# PLANNING BOARD REPORT PORTLAND, MAINE

Bank/Office Building with Bank Drive-through, 20 Marginal Way  
Level III Conditional Use and (Level II) Site Plan  
Bangor Savings Bank, Applicant  
Project #: 2015-080  
CBL 113 A025001

Submitted to: Portland Planning Board Public Hearing Date: July 14 <sup>th</sup> , 2015	Prepared by: Jean Fraser, Planner Date: July 10 <sup>th</sup> , 2015
--	---

AE203

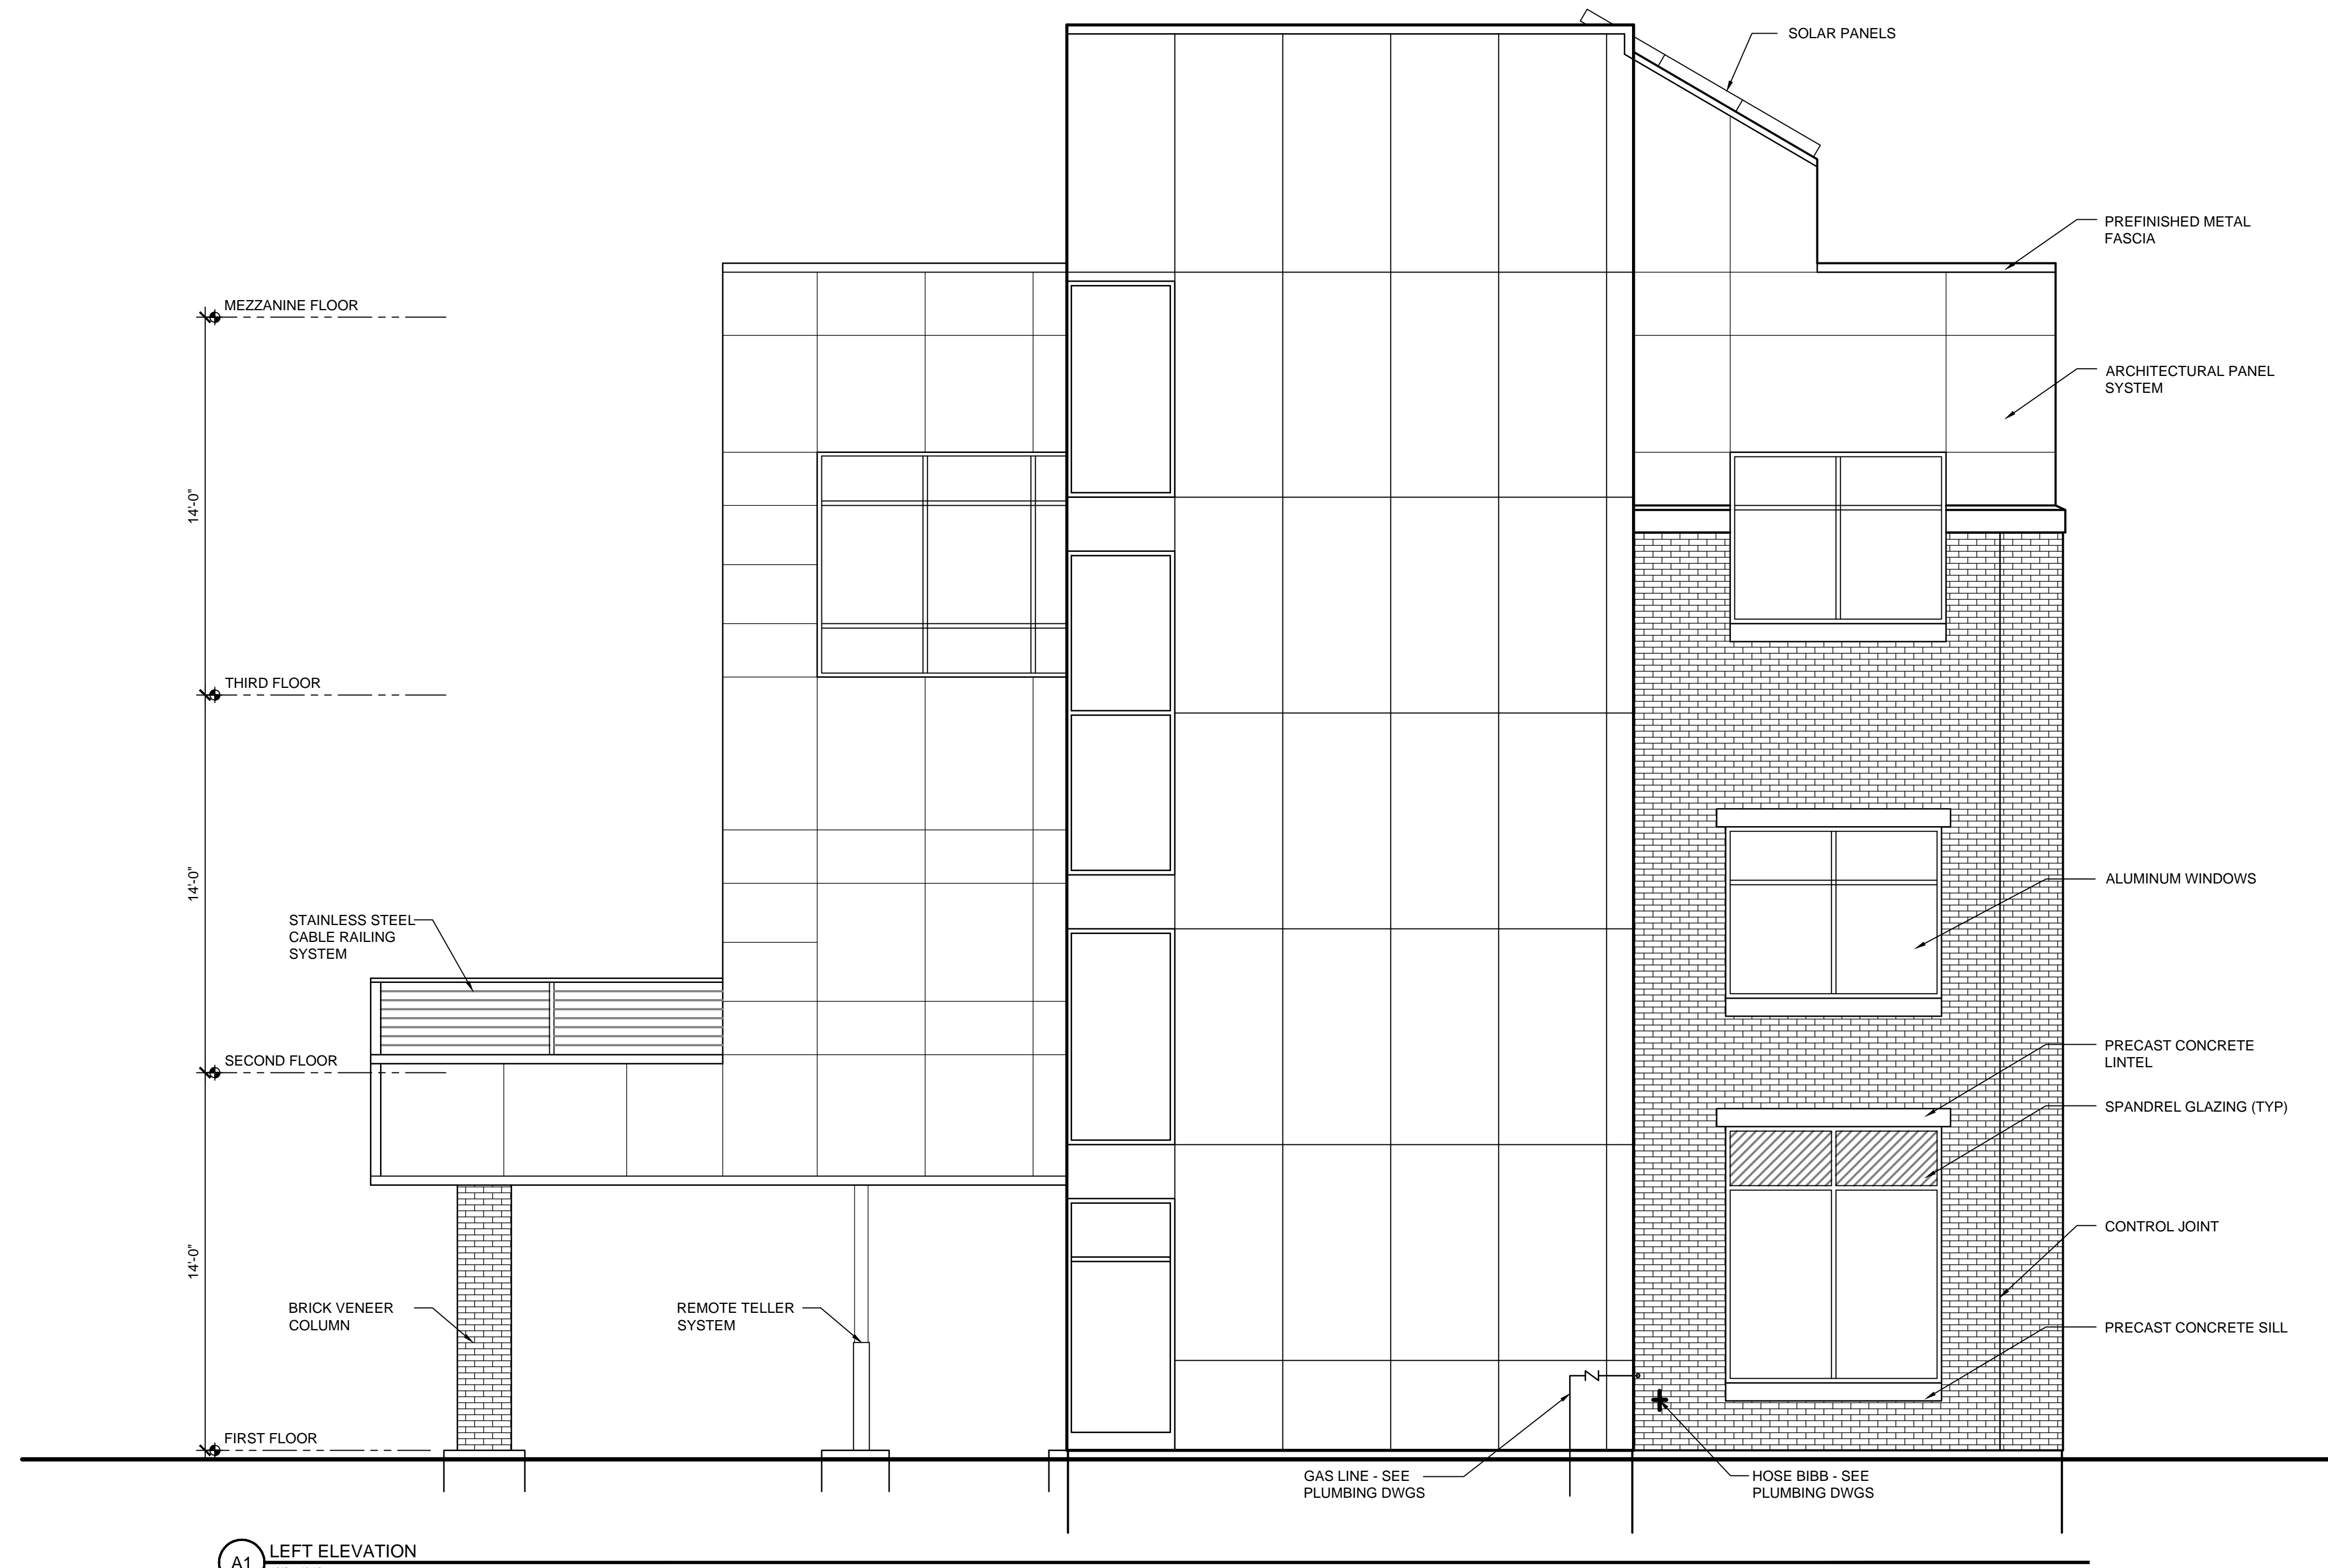
- Building Signage (see submission in Attachment H and Plan P12)
- Transparency and tinting of the glass, particularly along the south facing frontage next to the sidewalk (see submitted info in Attachment I)
- Landscaping to screen parking (see Plan P9 Landscape Plan and discussion above under Site Plan)

Staff recommends a condition of approval that requires the applicant to work with staff to resolve the window design including transparency, color, and size to meet the intent of the B-7 Design Principles and Standards.

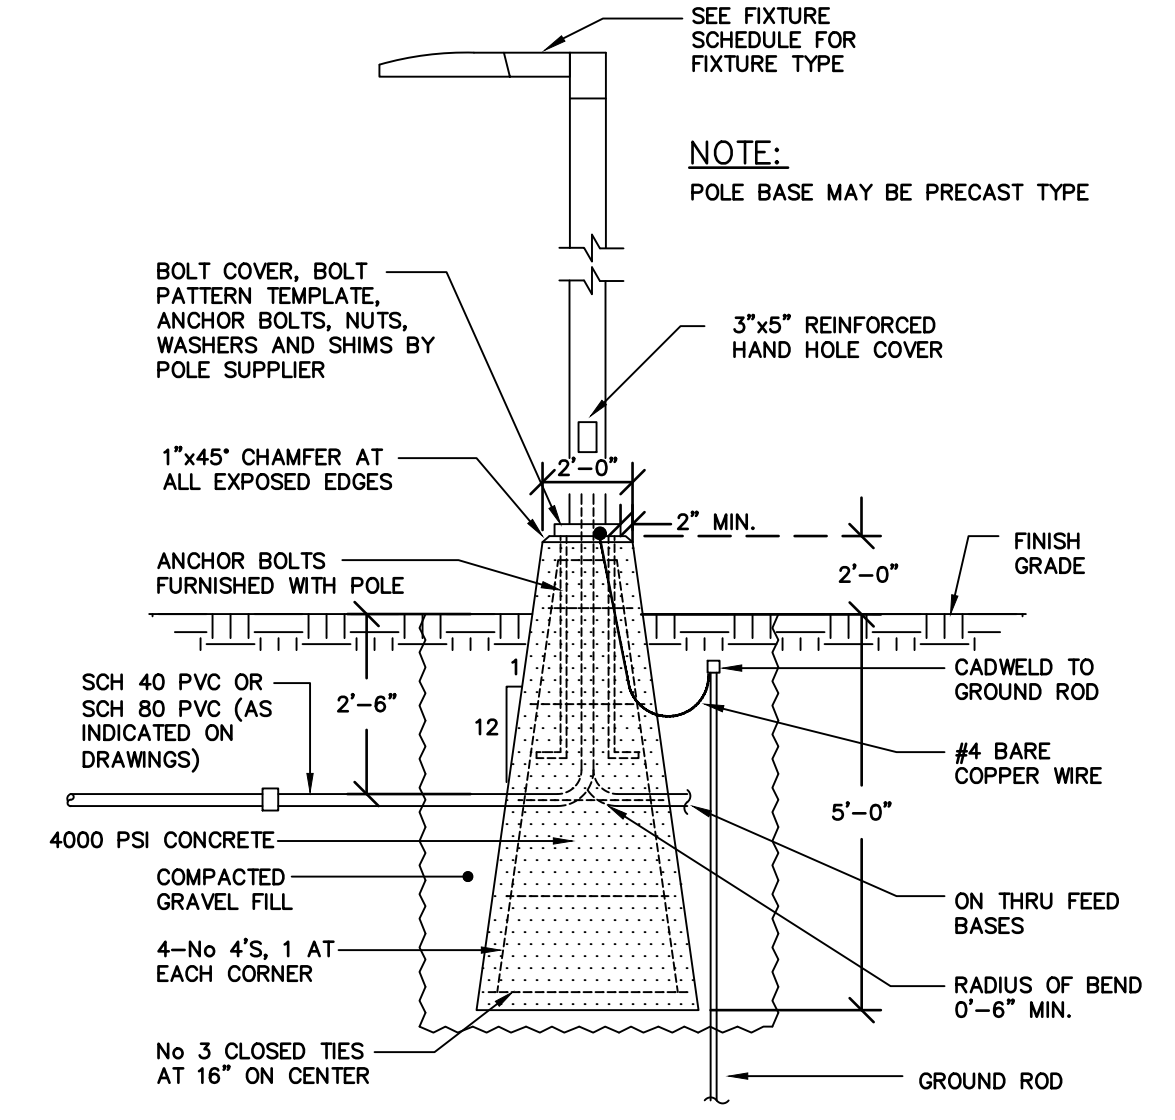
Exterior Lighting: The applicant has submitted a photometric plan at Plan P11. The plan omits some of the information required (such as the specs for the lights to confirm they are full cut-off) and shows levels considerably above the Technical Standards for trespass along the eastern boundary. While this boundary is not "sensitive" at this time, the high lighting levels could impact a future development or use.

As mentioned above under "Public Safety", the area of the drive-through is not overlooked from the sidewalk and increased lighting levels should be incorporated here to improve security. Staff recommend a condition that requires a revised lighting plan with further details and revised levels to meet these concerns.

- viii. That the applicant shall submit, for review and approval by the Planning Authority prior to the issuance of a building permit, a revised photometric plan for the rear parking lot area that includes the lighting fixture specification, reduces trespass along the eastern boundary to meet Technical Standards, and increases the lighting levels in the vicinity of the drive-through; and
